PLANNING APPLICATION R/77/26/S73: 15 EVELYN AVENUE BN16 2EJ

My wife and I are writing as the owners of 17 Evelyn Avenue to object to the proposal (R/77/26/S73) to reinstate the extensive cladding that was removed from the previous application (R/31/26/HH). The cladding at the sides would be clearly visible from the street and the cladding on the rear dormer would make it even more intrusive.

Proposed Roof Plan
1:200 @ A3

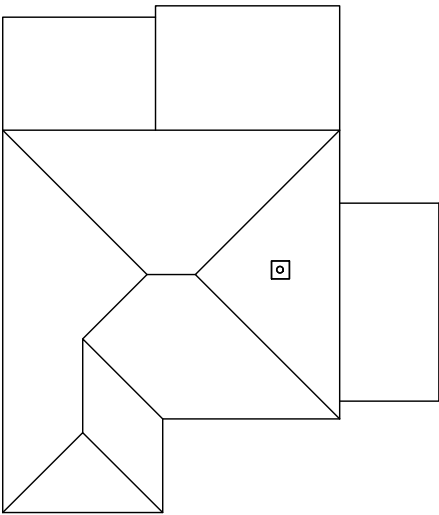
Regarding the rear dormer, the Case Officer's Report on R/31/26/HH confirmed that as proposed it "would not strictly comply with the ADG or RNP policy 2 and would not be a subservient addition within the rear roof slope". It was dismissive of neighbours' concerns about this but the reversion to cladding would make it even more obtrusive for us.
